**WELWYN HATFIELD BOROUGH COUNCIL
EXECUTIVE DIRECTOR - PLANNING, PUBLIC PROTECTION AND GOVERNANCE**

Application No: 6/2020/2046/LAWP
Location: Meadow View Wyndham Cottage Camfield Place Kentish Lane
 Hatfield AL9 6JE
Proposal: Certificate of lawfulness for proposed side dormers
Officer: Mr Tom Gabriel

Recommendation: Refused

4.	Plan Number	Revision Number	Details	Received Date
	222		Proposed Plans and Elevations	13 August 2020
	14111-S-001-1st		Survey Drawings	13 August 2020

14111-P001-B

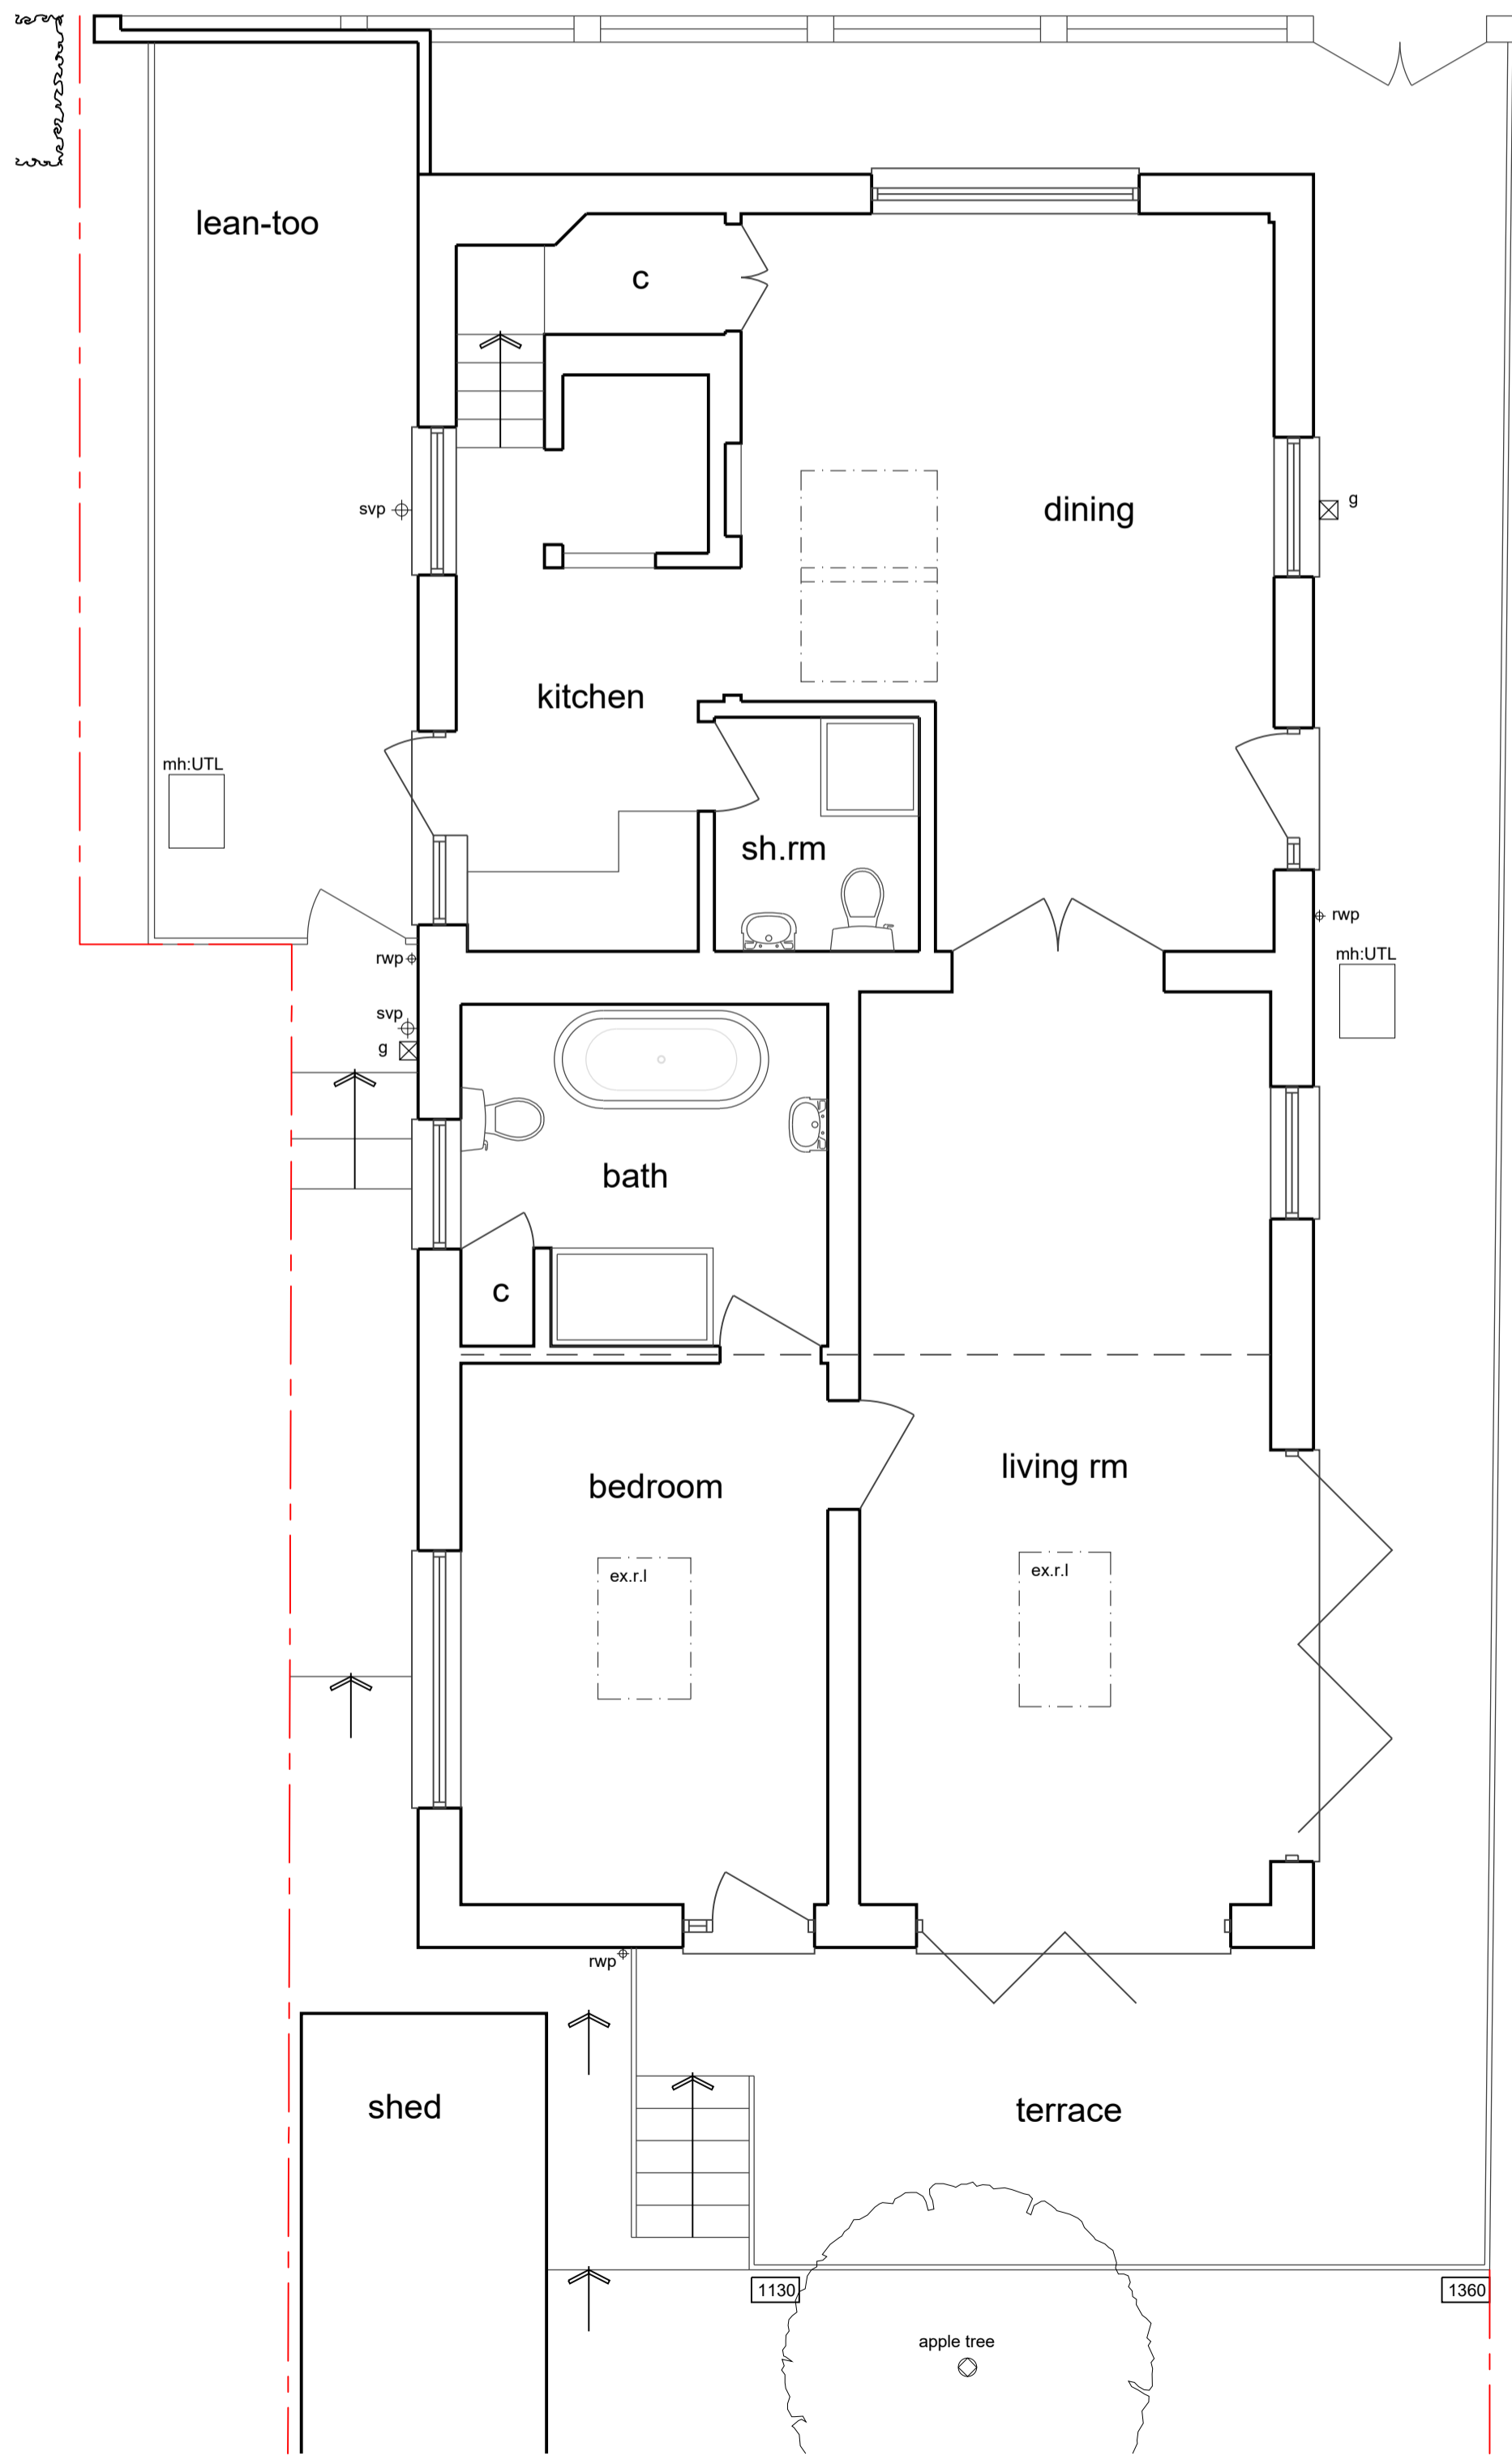
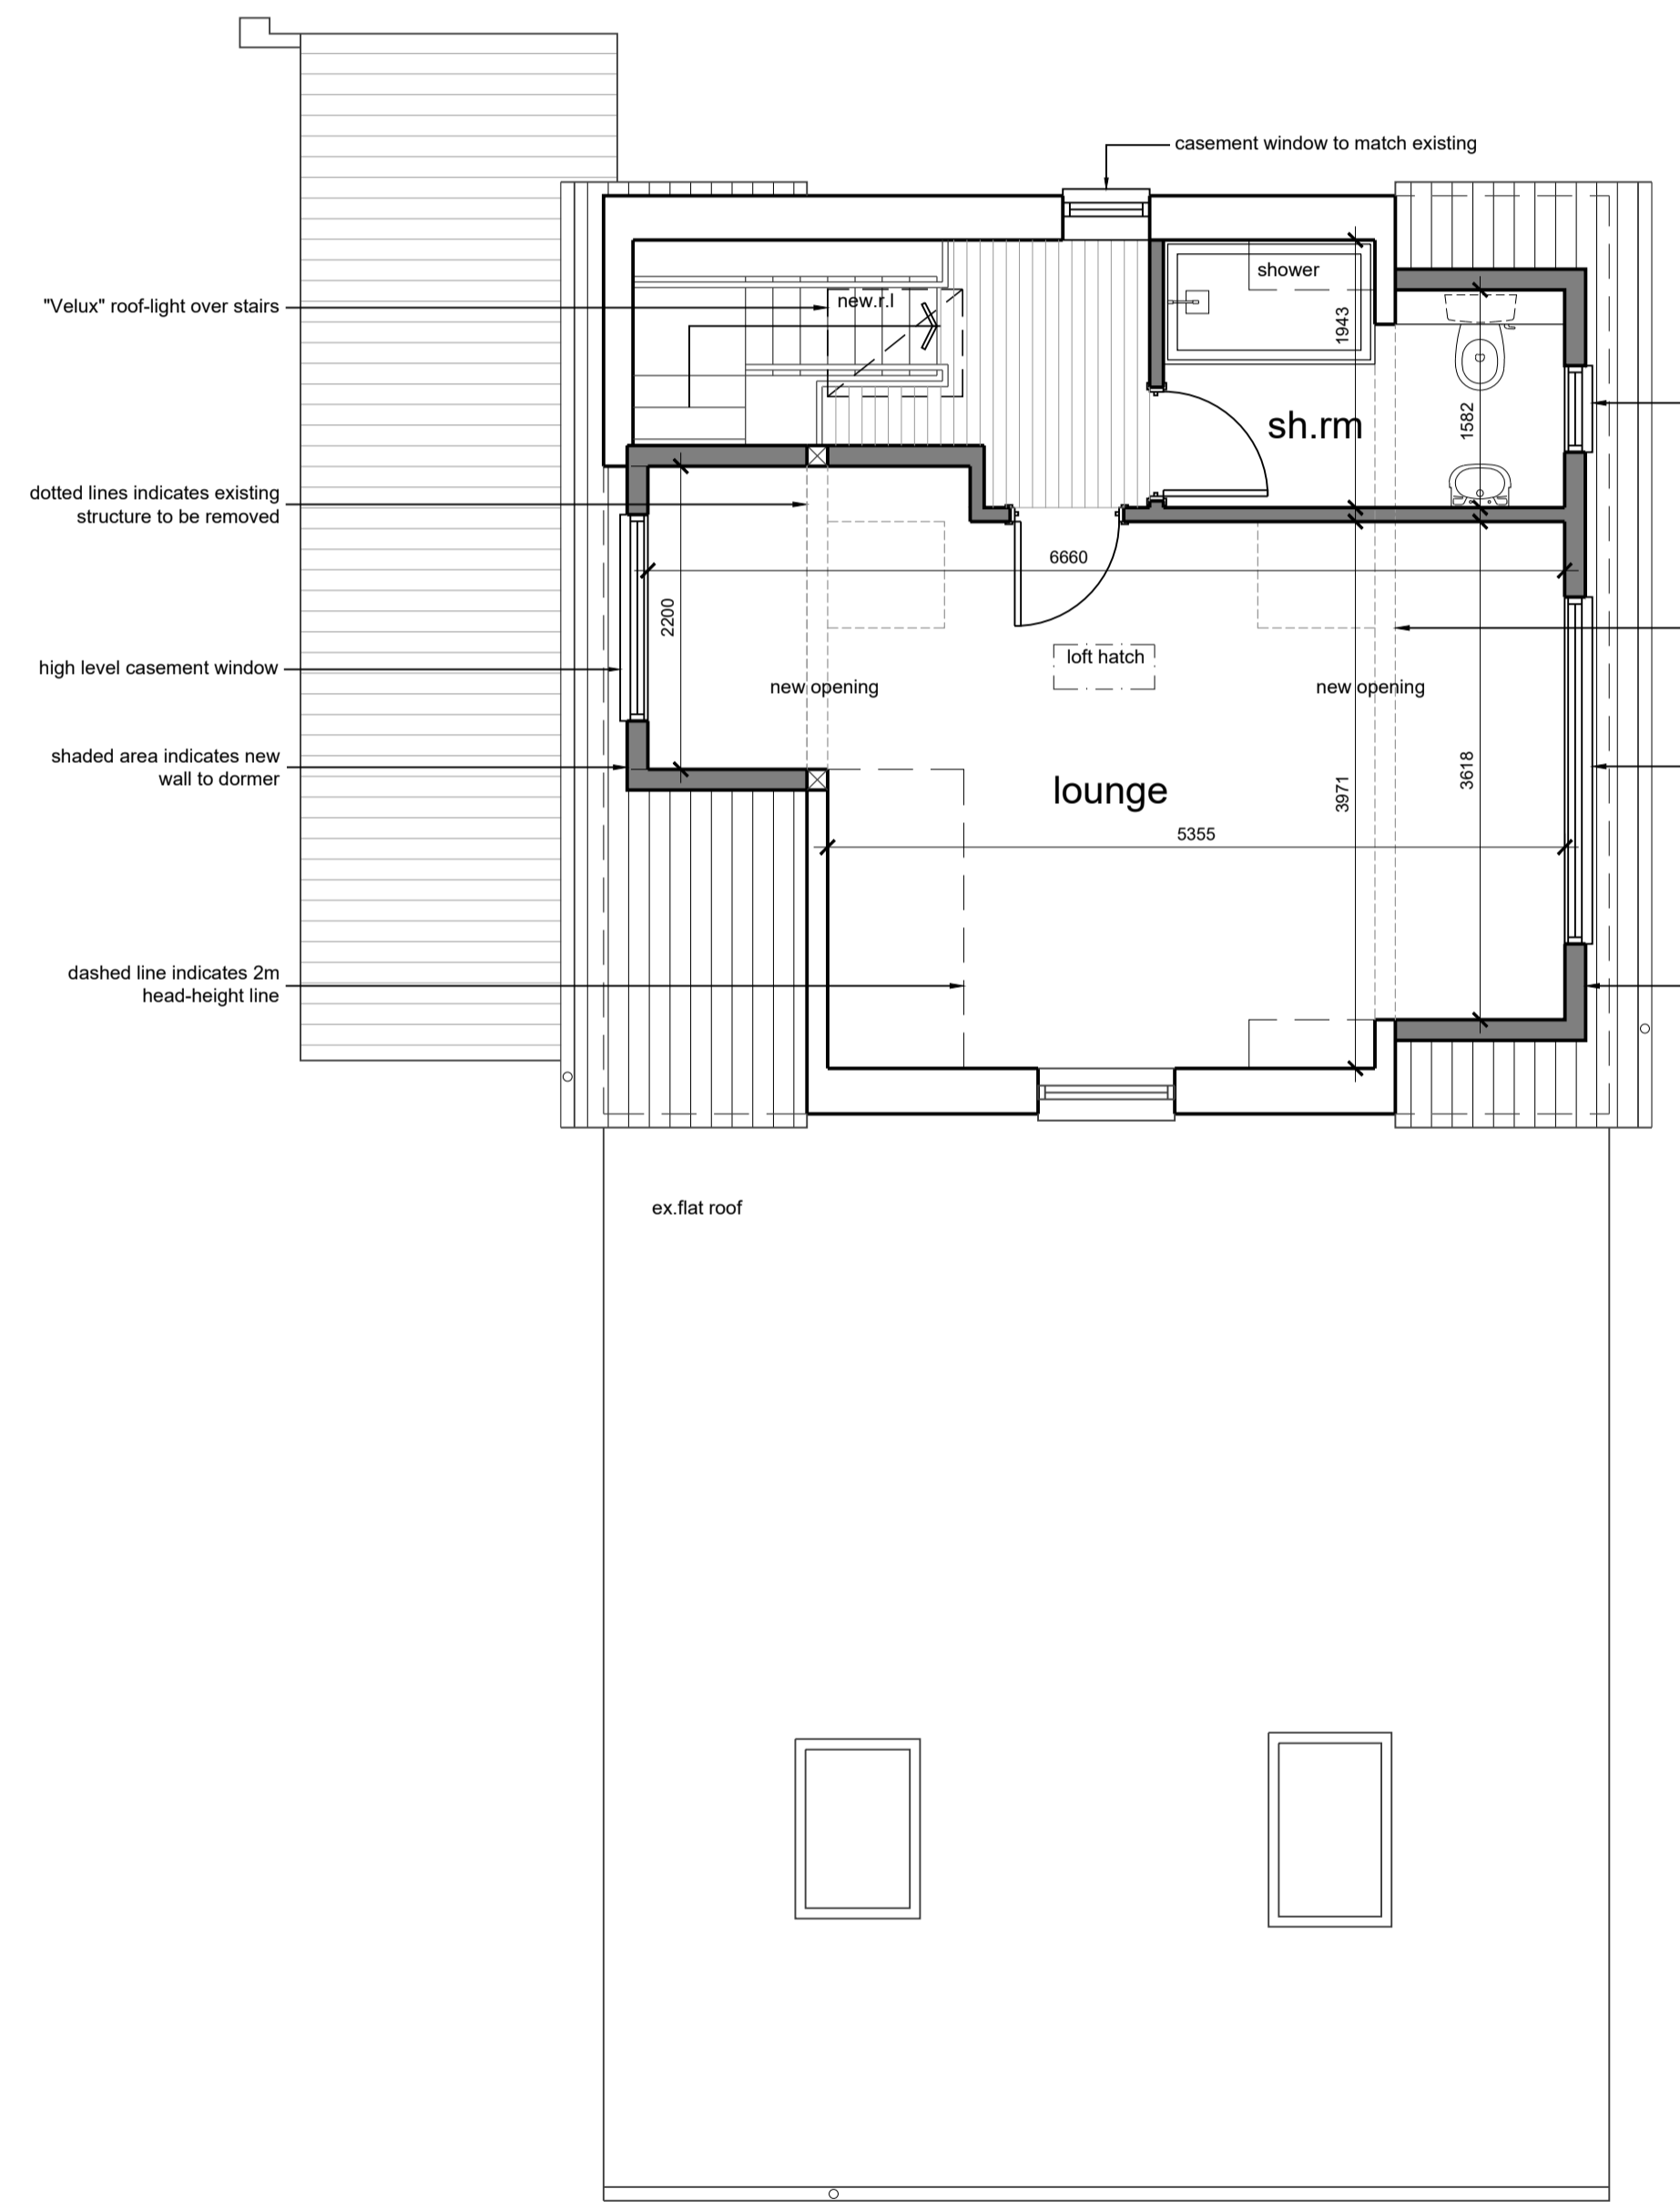
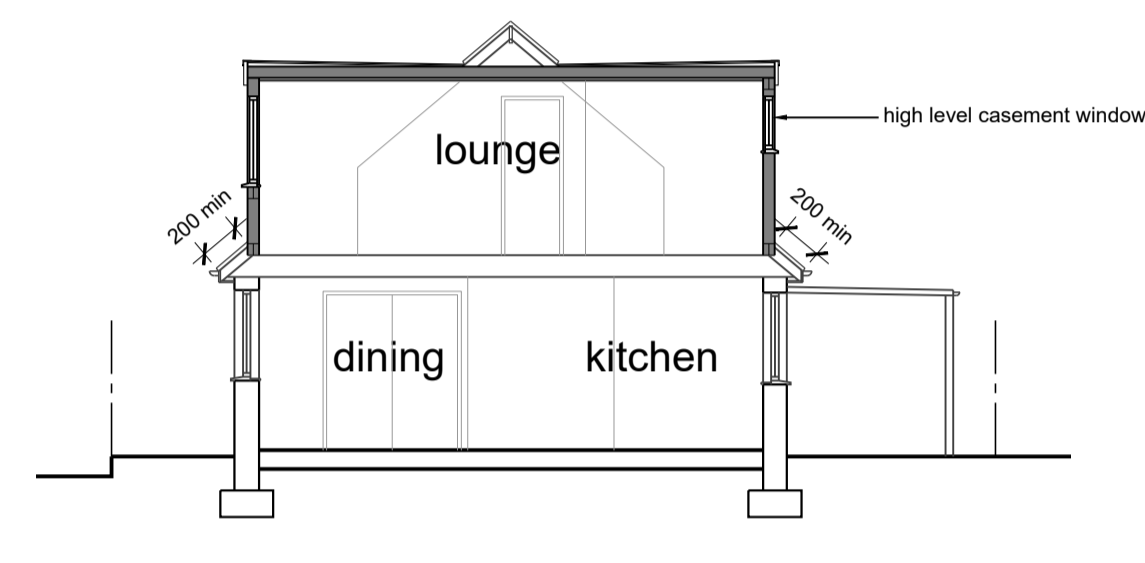
(d) would the cubic content of the resulting roof space exceed the cubic content of the original roof space by more than:- (i) 40 cubic metres in the case of a terrace house, or (ii) 50 cubic metres in any other case	N see below	N
<p><u>Calculation</u></p> <p>Big dormer: $(1/2 \times (5.75 (w) \times 2.2 (h) \times 2.4 (d)) = 14.7 \text{ m}^3$</p> <p>Little dormer $(1/2 \times (2.7 (w) \times 2.2 (h) \times 2.4 (d)) = 7.13 \text{ m}^3$</p> <p>Total = 21.83 m³</p>

<p>B.2 Development is permitted by Class B subject to the following conditions:-</p> <p>(a) the materials used in any exterior work shall be of a similar appearance to those used in the construction of the exterior of the existing dwellinghouse</p> <p>(b) is the enlargement constructed so that-</p> <p>(i) other than in the case of a hip-to-gable enlargement or an enlargement which joins the original roof to the roof of a rear or side extension –</p> <p>(aa) the eaves of the original roof are maintained or reinstated: and</p> <p>(bb) the edge of the enlargement closest to the eaves of the original roof shall, so far as practicable, be not less than 20 centimetres from the eaves, measured along the roof slope from the outside edge of the eaves; and</p> <p>(ii) other than in the case of an enlargement which joins the original roof to the roof of a rear or side extension, no part of the enlargement extends beyond the outside face of any external wall of the original dwellinghouse.</p> <p>(c) any window inserted on a wall or roof slope forming a side elevation of the dwellinghouse shall be –</p> <p>(i) obscure-glazed, and</p> <p>(ii) non-opening unless the parts of the window which can be opened are more than 1.7 metres above the floor of the room in which the window is installed</p>	<p>N – not specified on the plans or in the application form</p> <p>Y</p> <p>Y</p>

C.2 Development is permitted by Class C subject to the condition that any window located on a roof slope forming a side elevation of the dwellinghouse must be— (a) obscure-glazed; and (b) non-opening unless the parts of the window which can be opened are more than 1.7 metres above the floor of the room in which the window is installed.	Not specified	Y
---	---------------	---

Conclusion
The proposed development incorporating two side dormer windows and one side velux window may not be classed as permitted development and therefore requires planning permission.

1. The proposal fails to be classed as permitted development as the permitted development rights for the dwelling were removed when permission was granted for it.
2. The proposal has been assessed against and fails to comply with the conditions and limitations of Schedule 2, Part 1, Class B of The Town and Country (General Permitted Development) Order 2015 (as amended) as the materials for the development have not been specified.
3. The proposal has been assessed against and it is not known whether it complies with the conditions and limitations of Schedule 2, Part 1, Class C of The Town and Country (General Permitted Development) Order 2015 (as amended) as it has not been specified how far the velux window would project from the roofslope and whether that part of the velux window 1.7m above internal floor level would be obscure glazed and non-opening.
